R O N A L D L . K N O T T , P . E .

June 7, 2020

RE: Engineering Review Inspection Issues for 76 Virginia Lane, Cameron, NC

FLOOR FRAMING PLAN

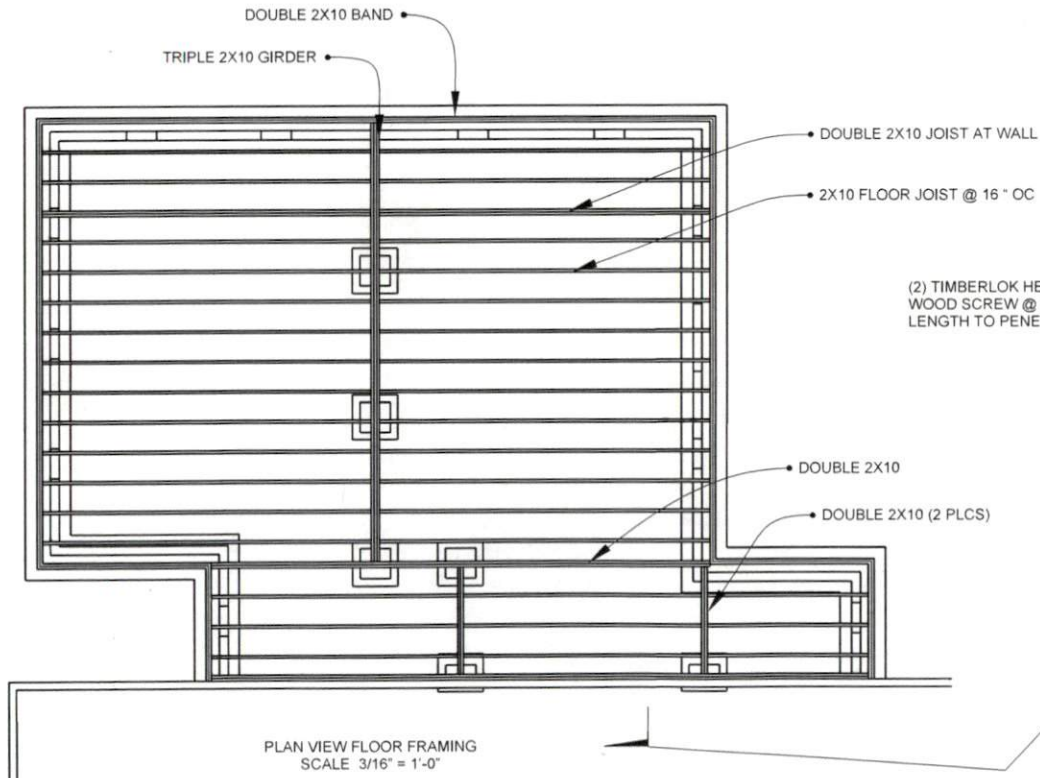
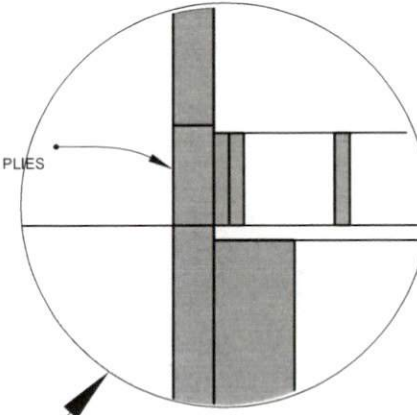
Item 3: The subfloor plywood thickness was specified to be 3/4". The use of 1/2" thick plywood for subfloor is acceptable.

WALL FRAMING PLAN

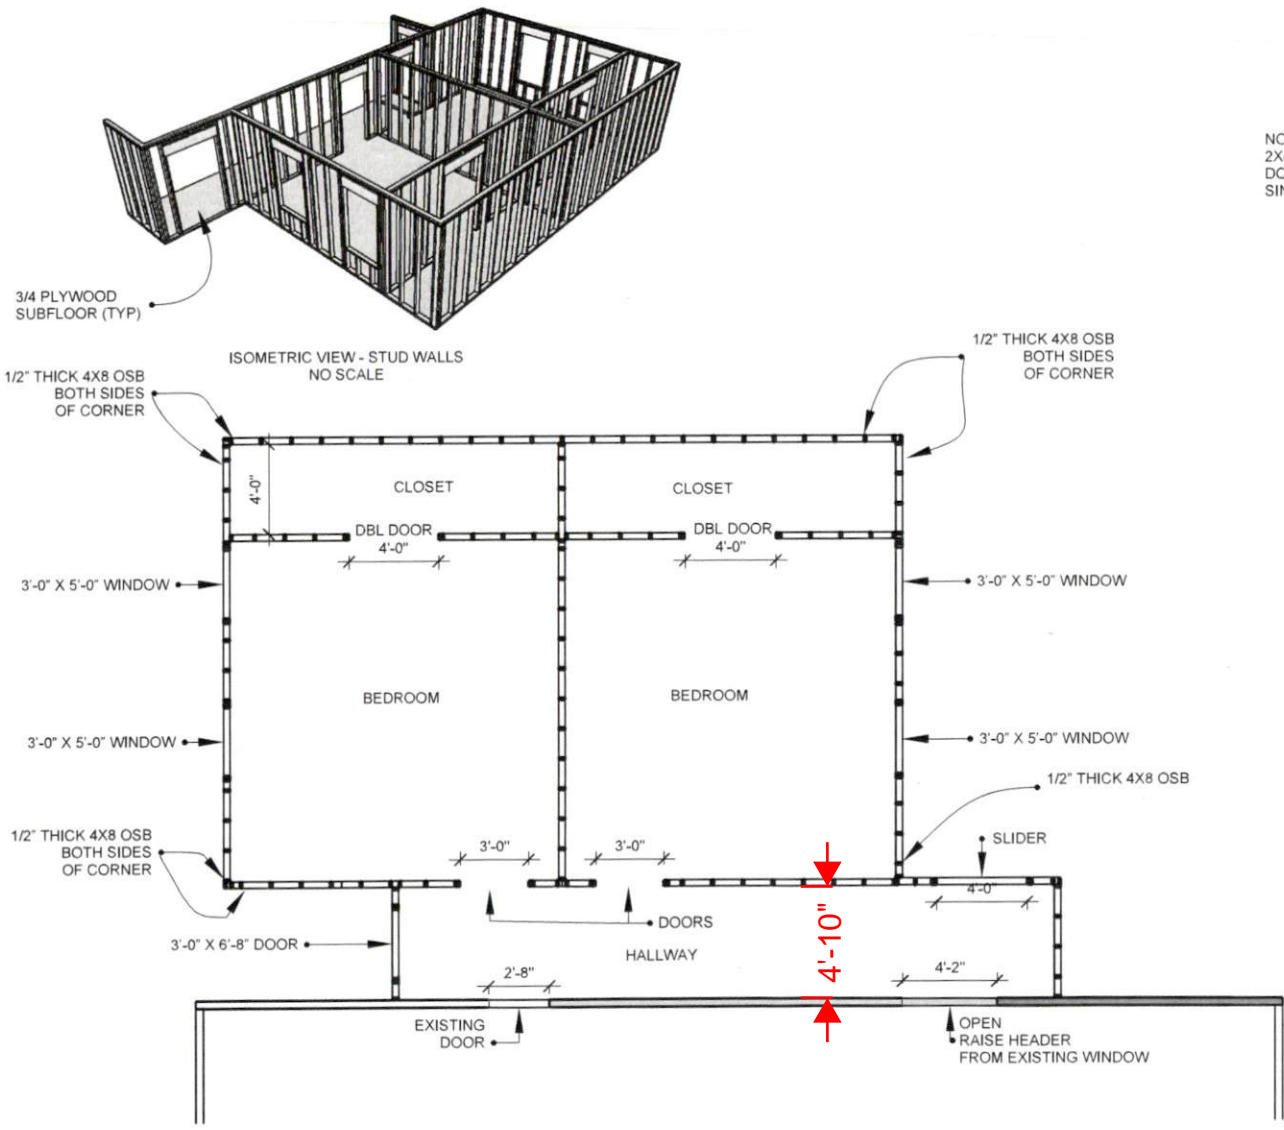
Item 2: Sheathing for wind bracing was specified to be 1/2" plywood at corners. However, 7/16" plywood was used all over. The reduction in thickness is acceptable considering the added area.

Item 5: Double 2x8 headers are acceptable for the exterior doors. Double 2x6 headers are acceptable for the interior doors. The sliding door has a header span of about 6 feet and a double 2x8 header is acceptable for that location also.

PLAN VIEW CEILING FRAMING
SCALE 3/16" = 1'-0"

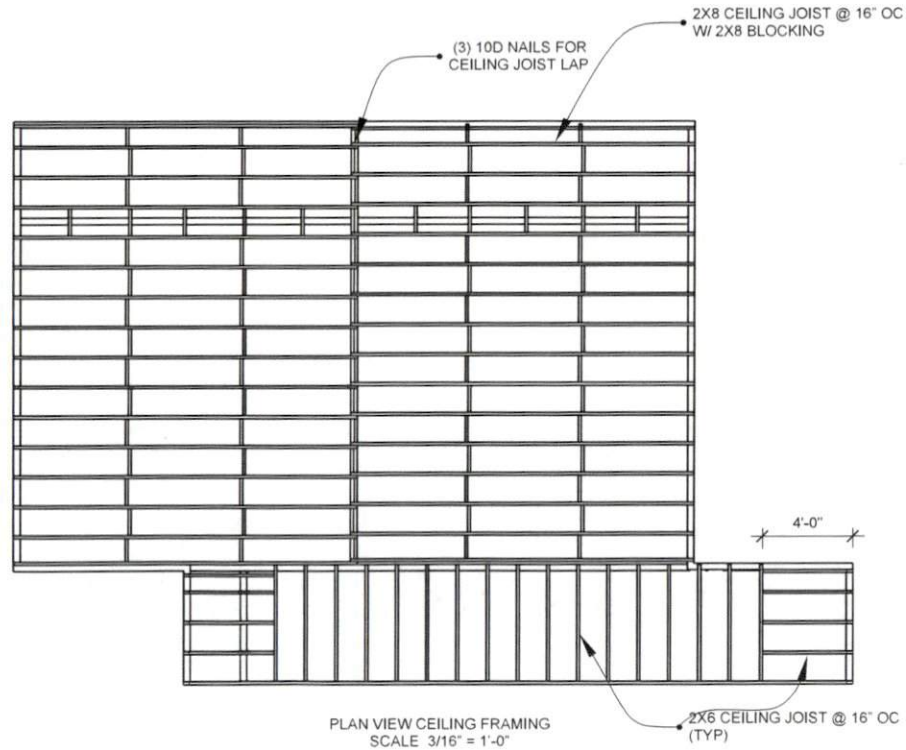
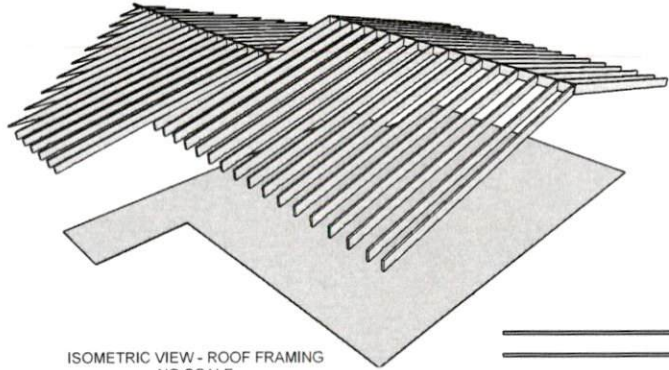
Item 1: Blocking was specified for ceiling joists over the two bedrooms. Instead, a plywood floor is being added above the joists. The nailing pattern will more than replace blocking for reduction of the unbraced length of the tops of the ceiling joists. Note: Some stability is also gained by sheetrock attachment to the bottoms of the ceiling joists.

Item 4: The taper on ceiling joists causes depth to be shallow at the support point. Additionally, the bird mouth cuts on the rafters cause a similar condition except for rafters, the heel is not supported. Since a spacer was used between the rafter and joist, the rafter will be predrilled and screwed to the spacer near the bottom of the rafter thereby preventing splitting of the rafter. Two #8 construction screws at least 2 1/2" long will be added at about 1 1/2" from the edge of each rafter and spaced about 3 1/2" apart.

Item 8: Studs under the ceiling joists in the hall area are supported on nailers attached to the side of the studs. These nailers have adequate nails and the joists are also nailed to the studs to allow use as supports without continuity to the sole plate.

Item 9: The joists in Item 8 are also nailed on their other end to the band of the existing structure with less than (4) 10d nails. The use of (3) 10d nails at this location is acceptable.
